## J156455 Addenda Report Greencap Response to Government Agency Recommendations

This report has been provided in response to Government Agency responses to the EIS submitted by Health Infrastructure NSW on for the proposed Tweed Valley Hospital project located at 771 Cudgen Road, Cudgen NSW.

## J156455 Addenda Report Greencap Response to Tweed Shire Council Recommendations

Drawing Title
**SOIL AND WATER MANAGEMENT
PLAN**

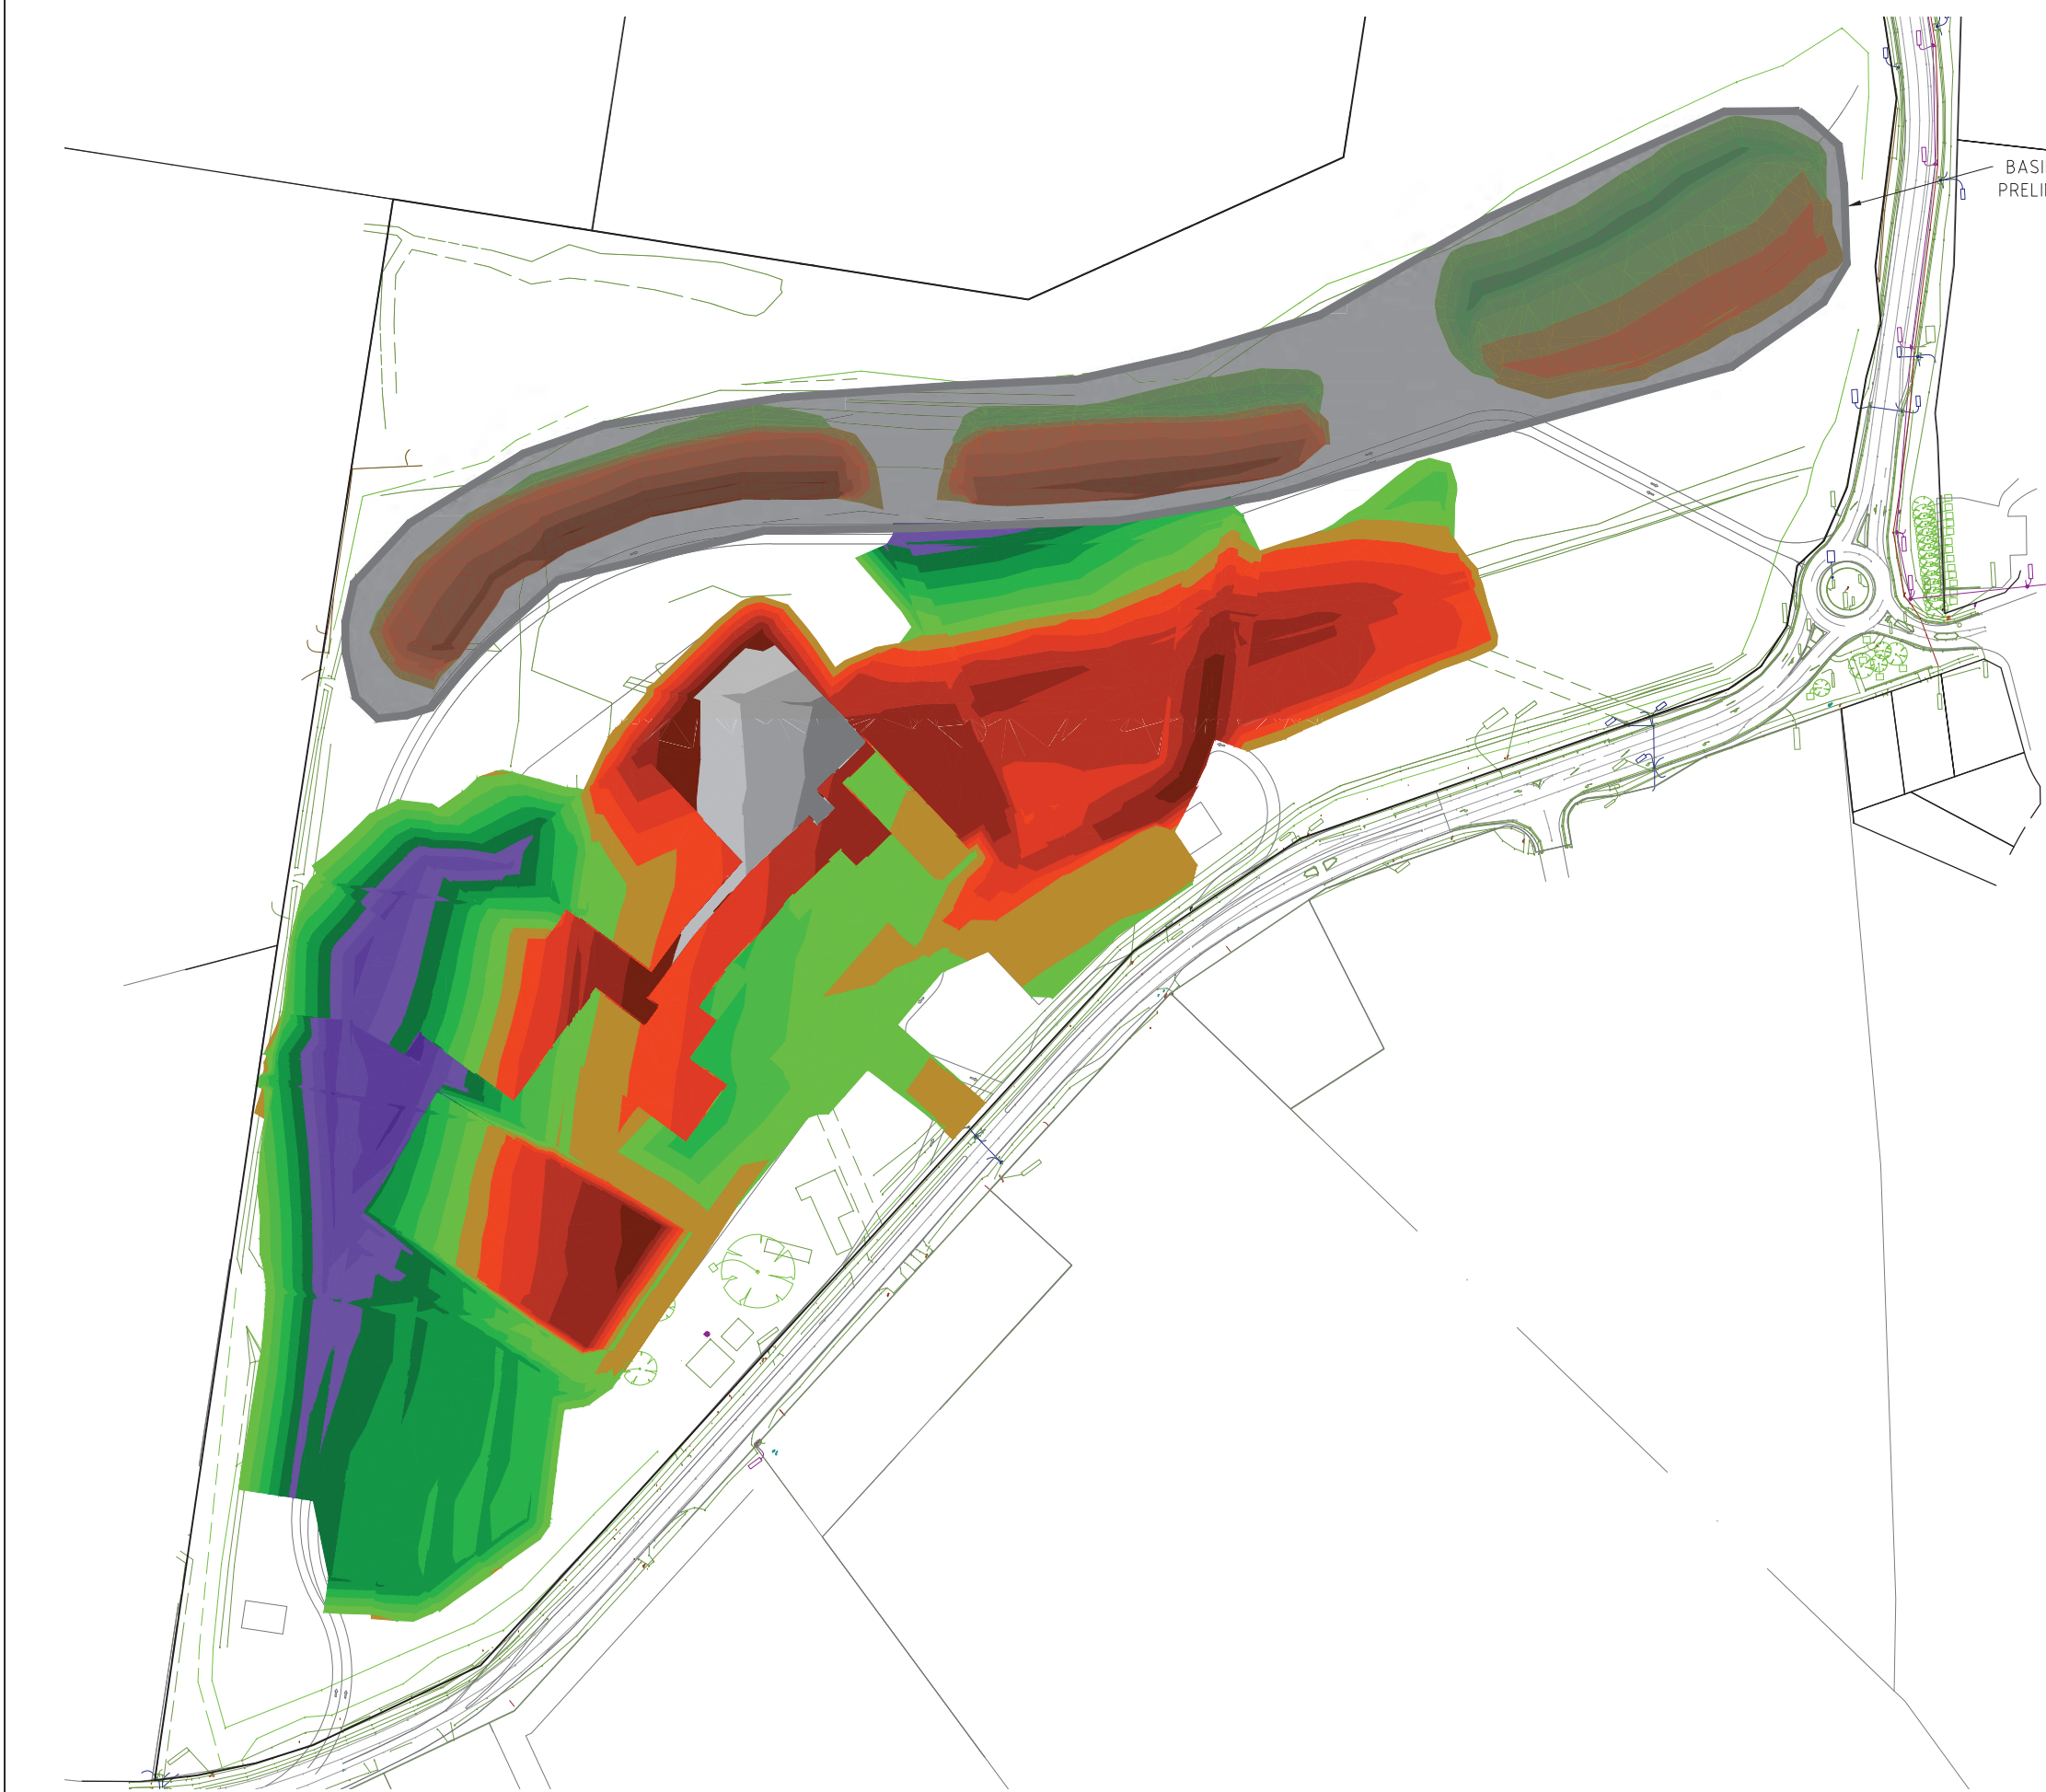
No	Reference Number	Recommendation	Response
	8.	<b>8. Ecology – the current proposal indicates three large sediment ponds hard up against the significant land to the north. A 50m buffer is normally required with the outer edge having some infrastructure.</b>	
1	<u>8 a)</u>	<p>It is recommended that further information is requested, or conditions of consent are applied, to achieve consistency with Tweed DCP A19 as follows:</p> <ul style="list-style-type: none"> <li>■ An amended development footprint that achieves a 50m ecological setback, to be managed as an ecological buffer, from the significant vegetation.               <ul style="list-style-type: none"> <li>– i. Overlap of APZ and sediment basin location with the ecological buffer may be acceptable if it can be demonstrated that the management requirements and design are compatible with ecological buffer management</li> <li>– ii. No more than the outer half of the ecological buffer is to be used for the above purpose.</li> </ul> </li> <li>■ Preparation and approval of a Habitat Management Plan for retained vegetation and ecological buffer.</li> <li>■ Implementation of the Habitat Management Plan should commence prior to commencement of any physical works on the site.</li> </ul>	<p>The Tweed Council DCP does not apply as Clause 11 of State Environmental Planning Policy (State and Regional Development) 2011 states that development control plans do not apply to State Significant Development.</p> <p>In addition to this SSD buffers and setbacks are determined through a Biodiversity Development Assessment Report which is considered and approved by NSW OEH.</p> <p>Details of alternative buffers are provided in the revised BDAR.</p>
